SEE LONGITUDINAL SECTION
IN DRAWING ML-ST 303 L-M6

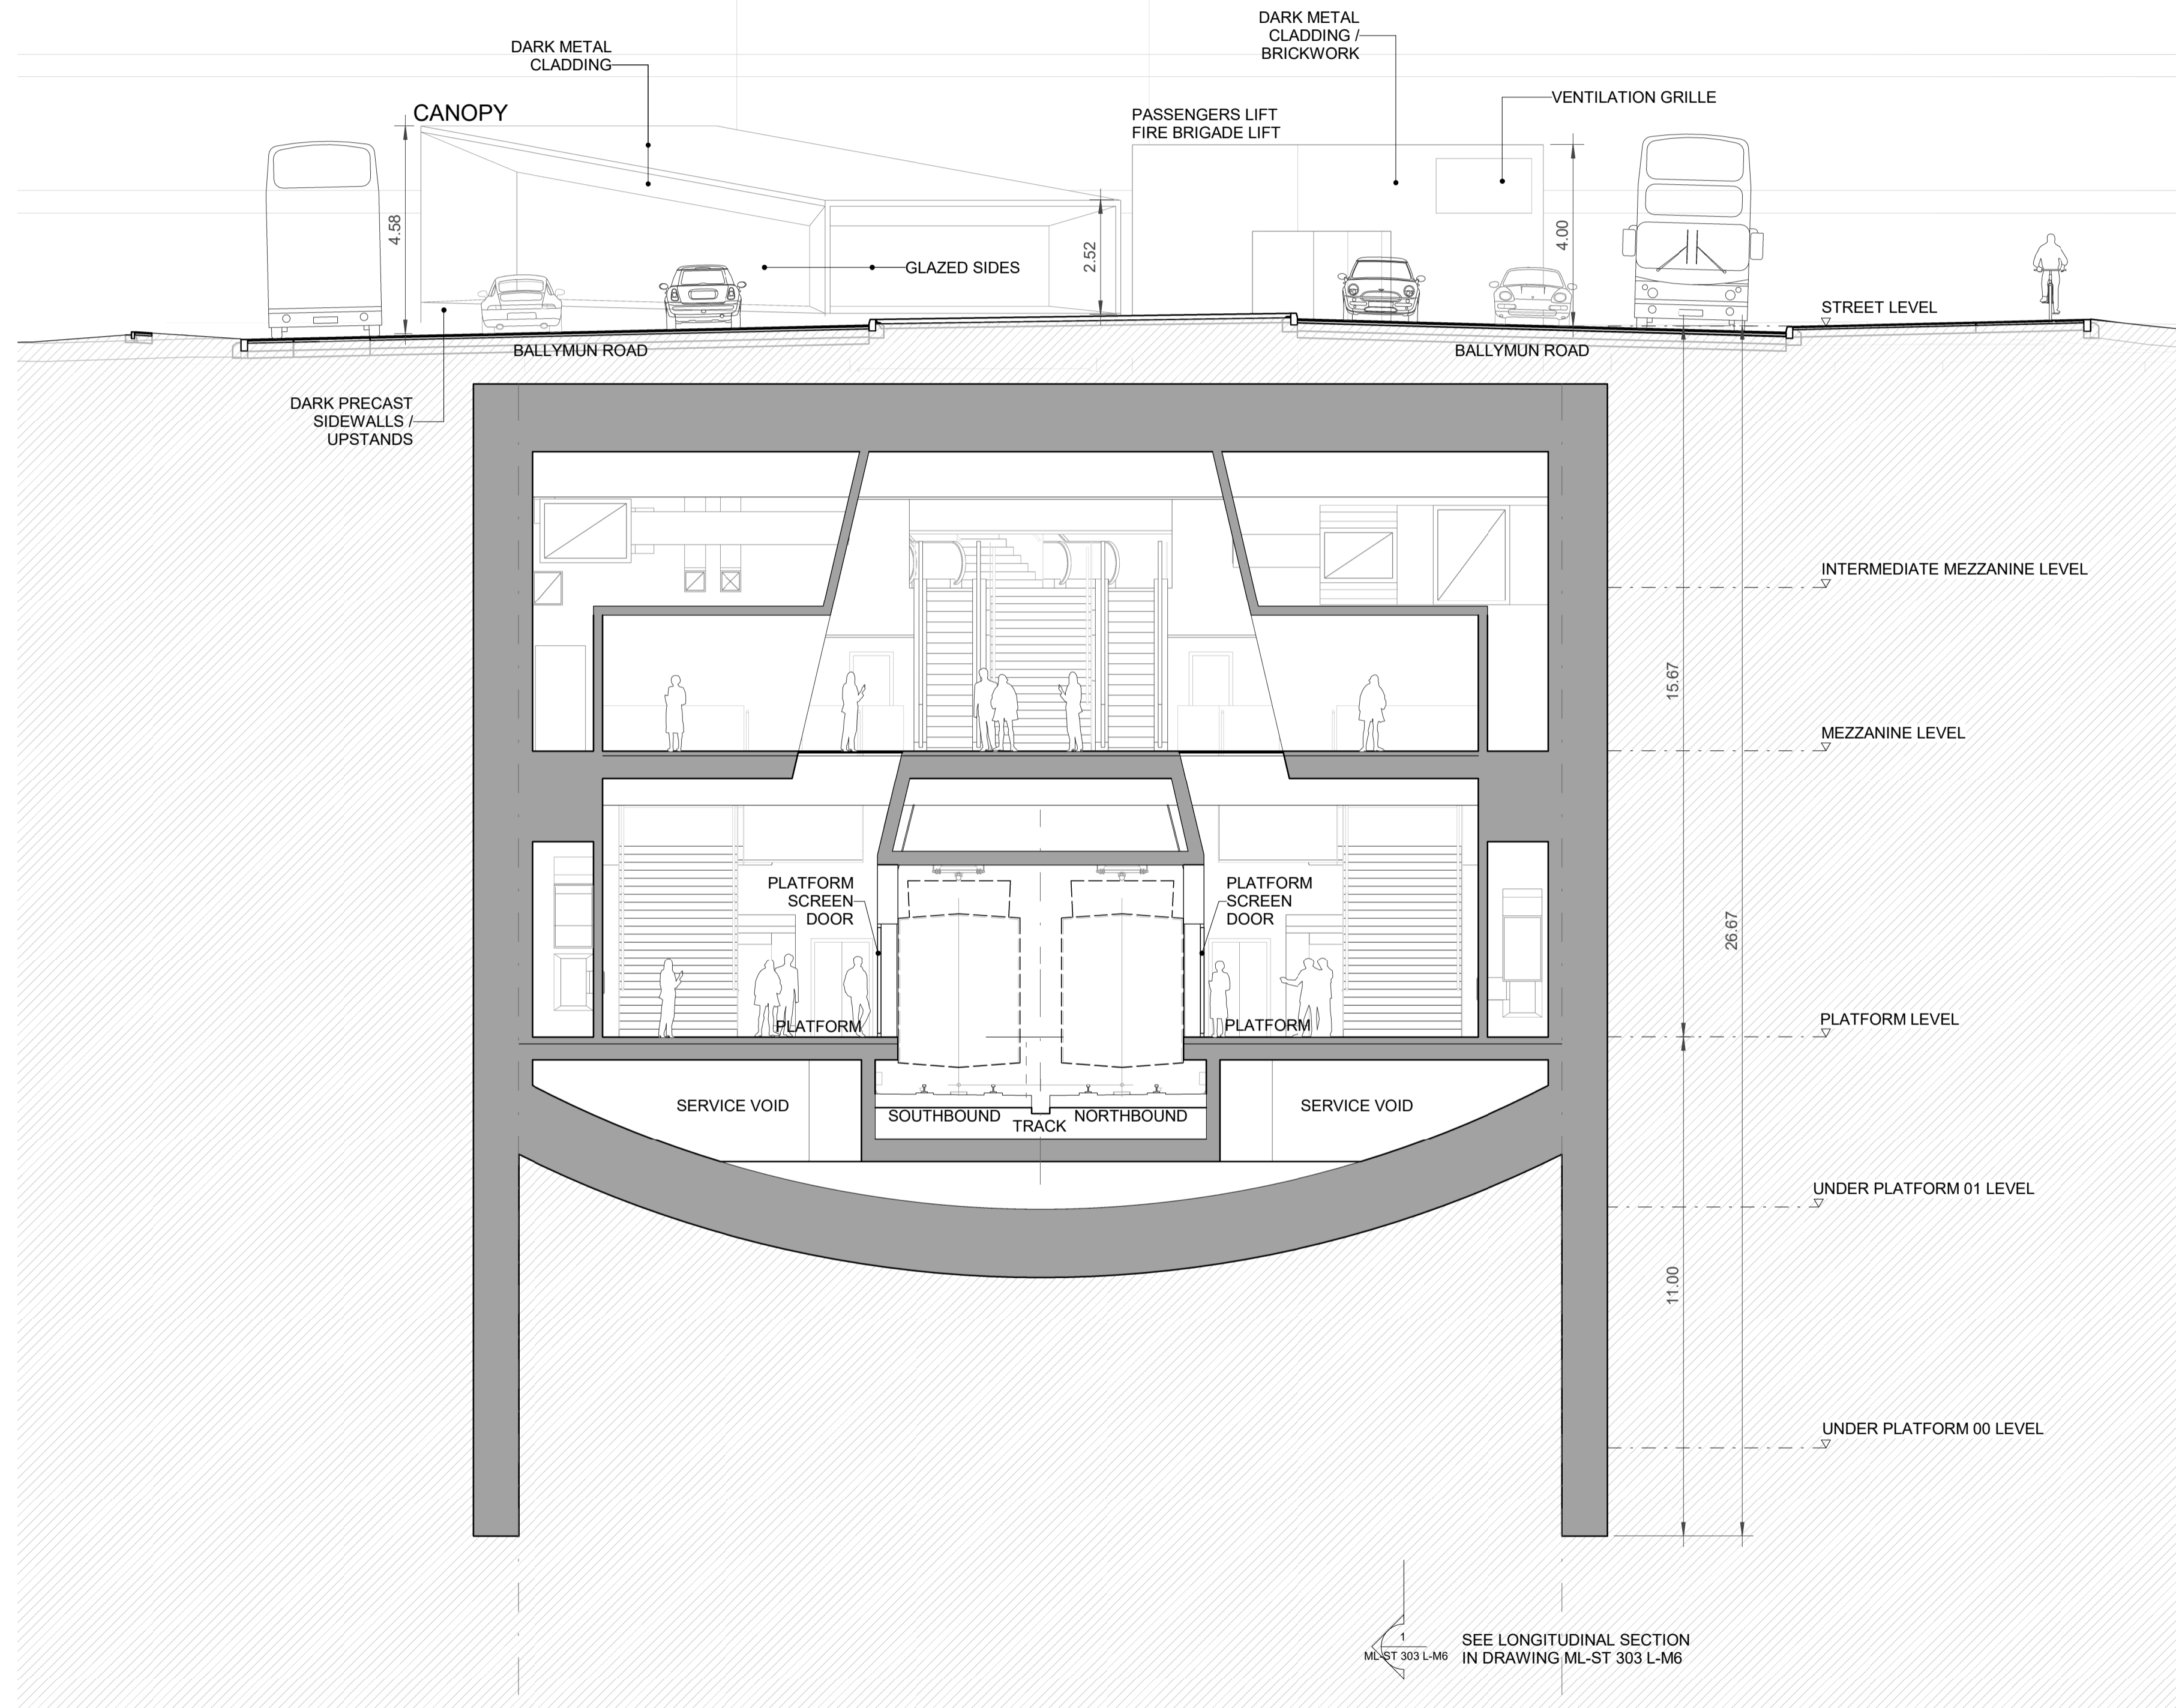
6	<i>Our client would wish to maximise the usable area of their site and would ask that the proposed Northwood station design/ layout be reconsidered to ensure it does not restrict development of the areas to be handed back and that over station development be considered further on the subject site.</i>	<i>Please refer to response item number (1) above.</i>	PUNCH Response: As 1 above.
7	<p><i>As part of a potential future mixed-use development of the subject site, our client, would look to provide a discount Food store on the site.</i></p> <p><i>The MetroLink proposals indicate two areas for potential development adjacent to the proposed station but other sections, such as the northern portion of the site (which the track alignment passes through) do not indicate potential for future development. Vehicle access and car parking provision is an important consideration for a discount Food store (in conjunction with sustainable modes of travel). Vehicle access to the site would likely have to be taken from the Old Ballymun Road positioned towards the northern end of the site (as proposed in the 2013 planning application, see Figure 2), given the layout of the surrounding road network. In turn, this</i></p>	<p><i>MetroLink public realm has been designed in consultation with Lidl by taking Lidl's future development plans into consideration. As discussed in several consultation meetings, the proposed Northwood Station construction works will require the acquisition of the entire site on a temporary basis and the acquisition of the western part on a permanent basis as shown on the RO property plans.</i></p> <p><i>Upon completion of the MetroLink construction works, the retained lands in consultation with TII, can accommodate development in line with zoning objectives, proposed development plans. However, design for any future building or structure immediately adjacent to MetroLink station and tunnel must take cognisance of the MetroLink structures and avoid impact, with the intention of preserving and optimising the scale and value of the Adjacent Site Development recognising that the operational requirements of the station are the overarching priority.</i></p>	Punch Response: As 1 Above

would predetermine access requirements for the car parking layout (both at surface and underground level) and the location of the loading servicing/ delivery facilities for a potential discount food store. As such, ABP in their consideration of the MetroLink proposals should seek to enable a larger area of the subject site be utilised for future development, allowing for the provision for a high-density mixed-use development.		
8	The MetroLink proposal indicates access to the station is to be facilitated by two main entrance points, one on either side of the Ballymun Road, as well as separate emergency access points. It is unclear from the proposal drawing if there are other access requirements to the station or track which our client would have to consider when planning future development. As such, further consideration should be given by ABP at this planning stage, and if necessary, consultation undertaken with our client.	There are two main pedestrian entrances to the station. There are additionally lift locations either side of Ballymun Road each comprising 2 lifts with one for Dublin Fire Brigade. There are additionally surface penetrations for, inter alia, smoke, ventilation and draught relief. TII will require maintenance access to these locations. With regard to development adjacent to the station please refer to Item number (1) above.	MCA Response: Proposed scheme does not overlap with pedestrian entrances or lift locations, based on the metro background information provided to Lidl to date. Any metro services penetrations that may coincide with the proposed scheme are proposed to be engineered so as to allow access for TII where required. It is assumed that a plenum zone below the Lidl store (between the Lidl store and metro station) will allow this measure of flexibility.
